Planning Inspectorate Examination EN010137: Mona Offshore Wind

Cefn Meiriadog Community Council
MNOW-ISP002

Deadline 4, 4 November 2024

Response of the Community Council to the Applicant's *Notification of Intention to Submit a Change Request Application*

Drawing Title:
WORKS PLAN - ONSHORE

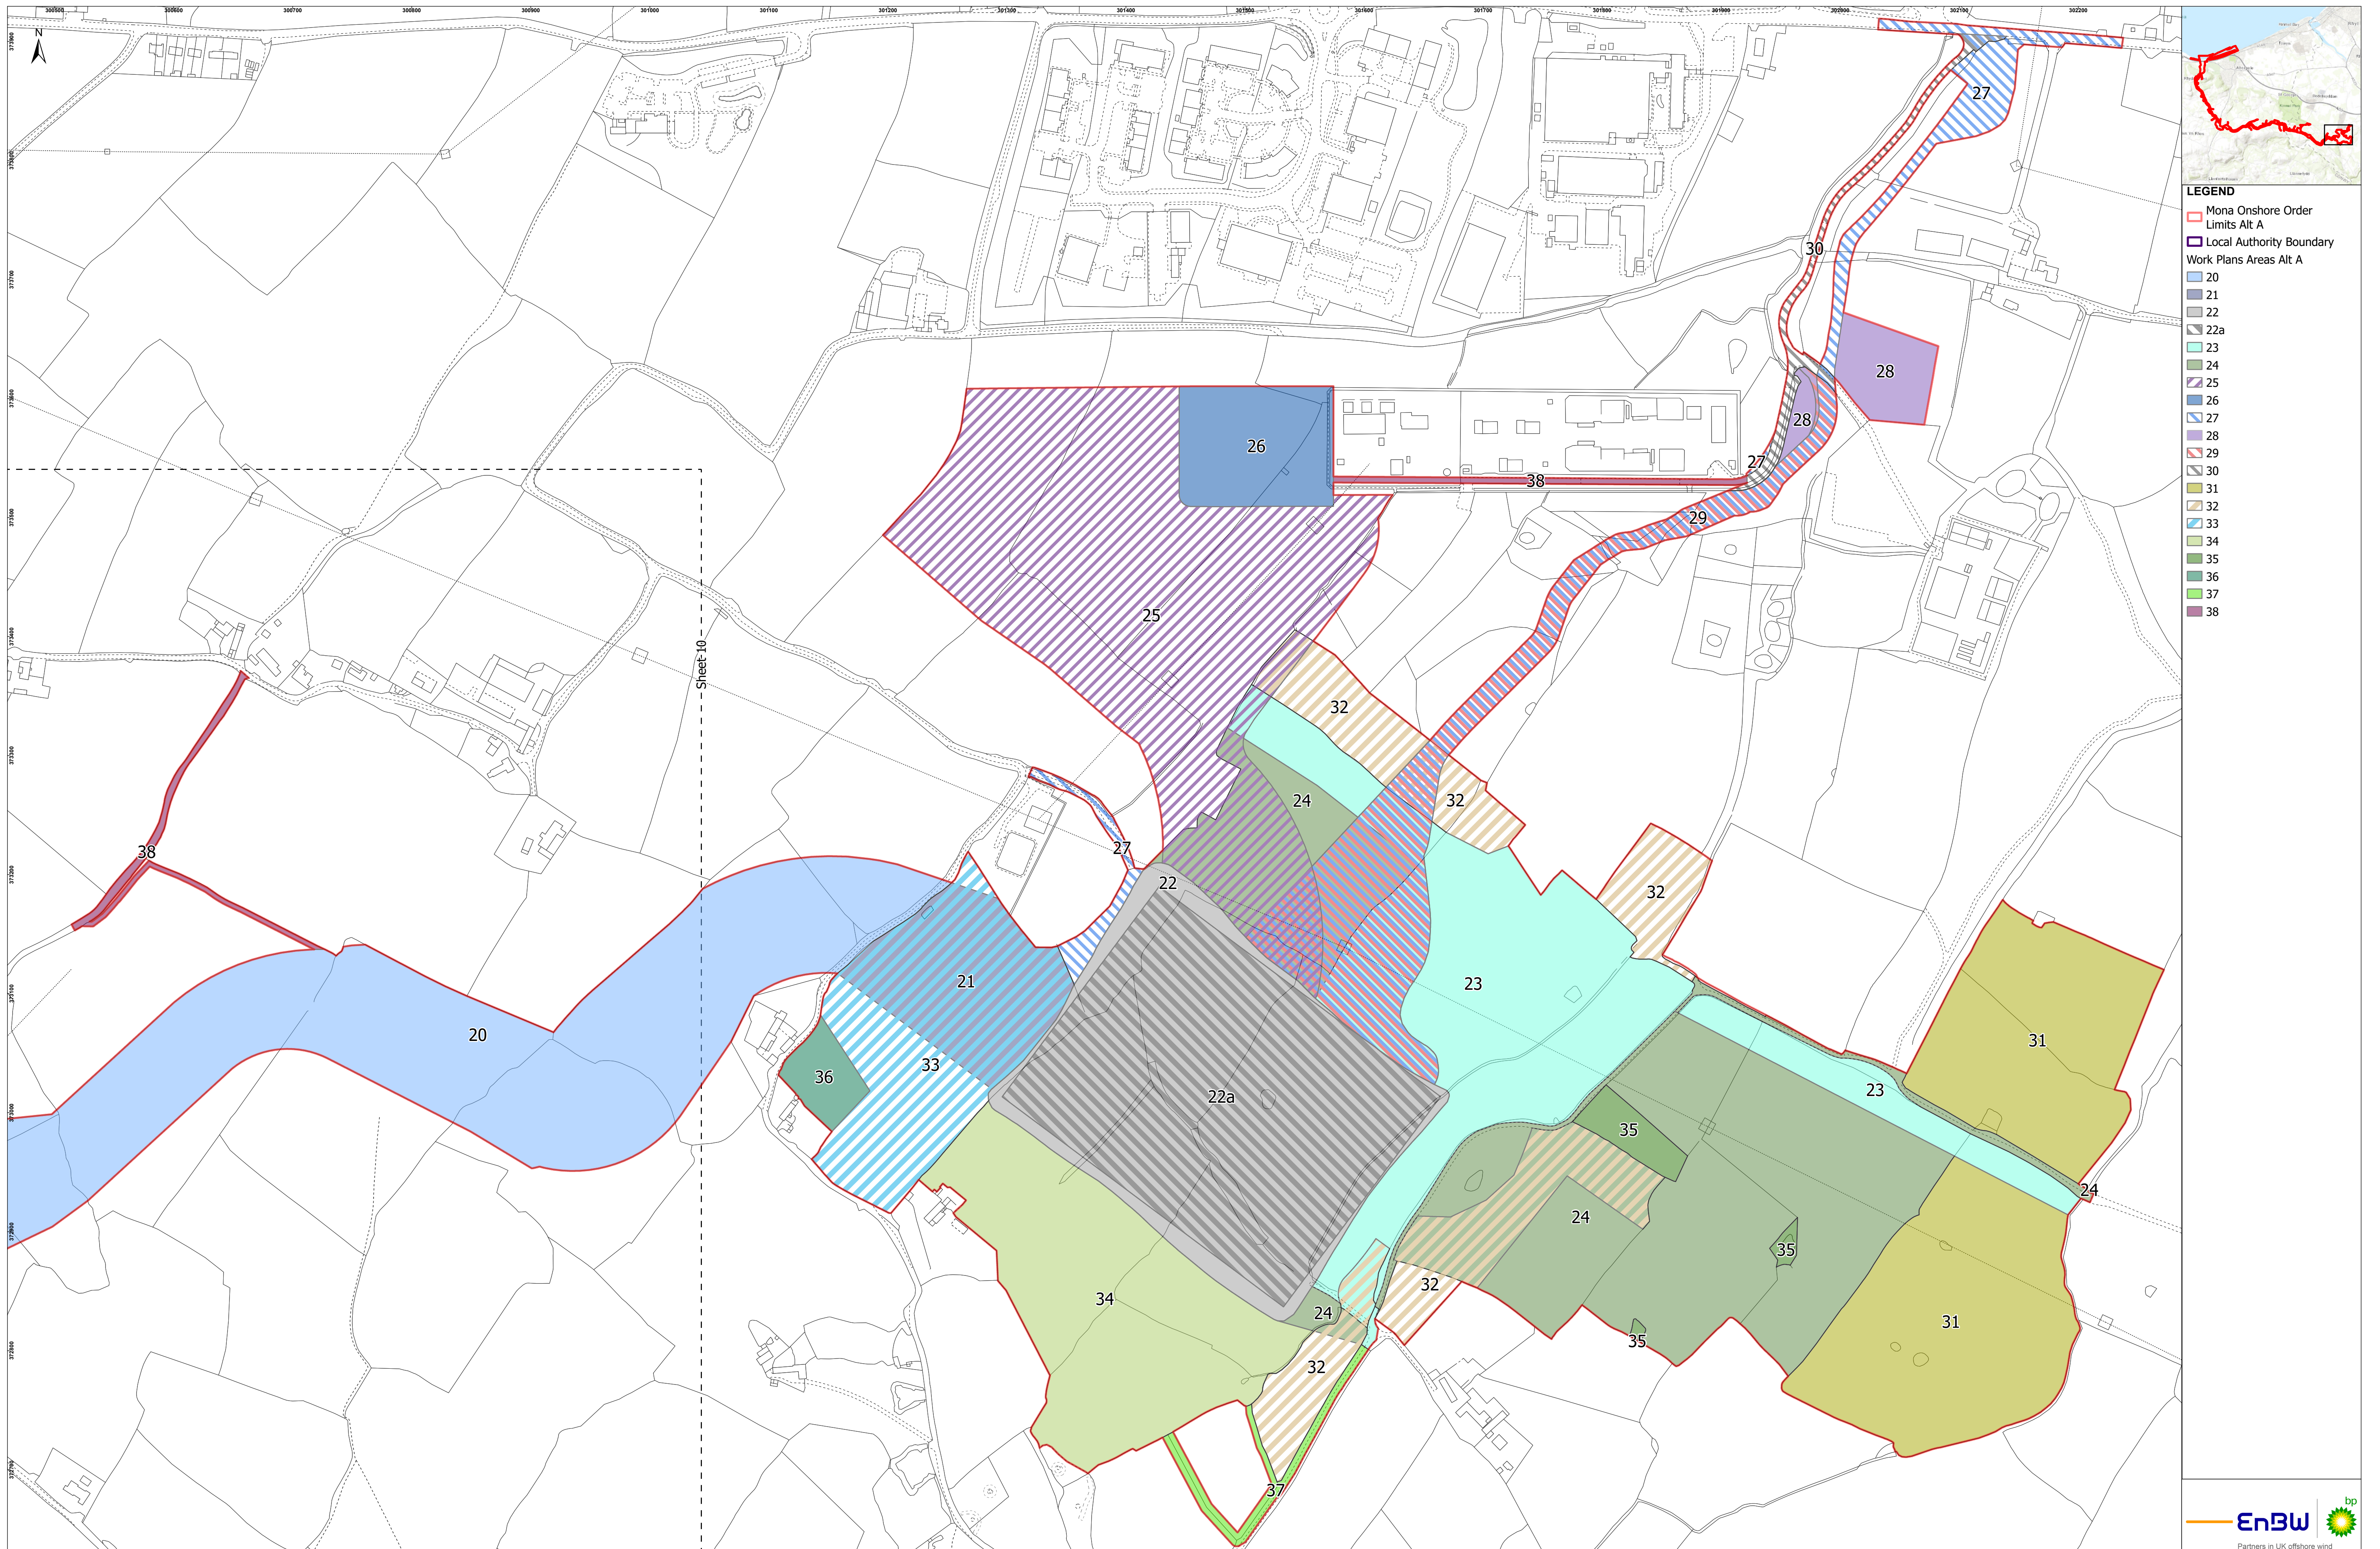
2. The Community Council expresses its serious concern over the change described in the Notification as 'Change 1a': i.e. *Order Limits change to include an existing access track to the west of the onshore substation for temporary construction access during onshore site preparation works and construction of the onshore substation and surrounding works.*

3. CMCC's concern is based on the assumption that from Glascoed Road the access track referred to will be itself be accessed via the minor road to the south of Glascoed Road and immediately to the west of the western edge of St Asaph Business Park.

4. If this assumption is correct, the Council objects strongly to this proposed change. If the assumption is incorrect, and the access track would be reached by other means, then the objection does not apply.

5. Even by the standards of Cefn Meiriadog's minor roads, beyond the property Waen Meredydd (situated on the first bend after leaving Glascoed Road), the road concerned presents particular difficulties for those using it. It is narrow with only one passing place; it has four right-angle bends between its starting point and the access track referred to; it has high hedges; and it has a significant gradient over a portion between two of the right-angle bends. In normal conditions visibility is poor due to the bends and high hedges, while in icy conditions the bends and gradient represent significant hazards. There is poor visibility at the junction with Glascoed Road, making access to Glascoed Road from the

8. From its long familiarity with the road and the residents using it, CMCC strongly believes that the use described is inappropriate, in particular the implication (e.g. “land reprofiling for landscaping”) that it will be used by large vehicles.

9. It is also noted that the Notification states that the access track will be used not just for site preparation but during construction also, implying that the minor road could if necessary be used during the construction phase, even if the principal access to the access track for the construction phase has by that time been constructed elsewhere.

10. The Council believes therefore that, if its assumption is correct and the minor road in question will be used for access, it will be a completely inappropriate use of a public road and will impact negatively on the community. It disagrees strongly with the Applicant’s assertion in the Notification that “...none of Changes 1 – 5 will result in any new or different likely significant environmental effects. Overall, therefore the Applicant does not consider that the proposed changes would result in a materially new or materially different impacts and they are capable of being accepted as an in-Examination change to the Application”.
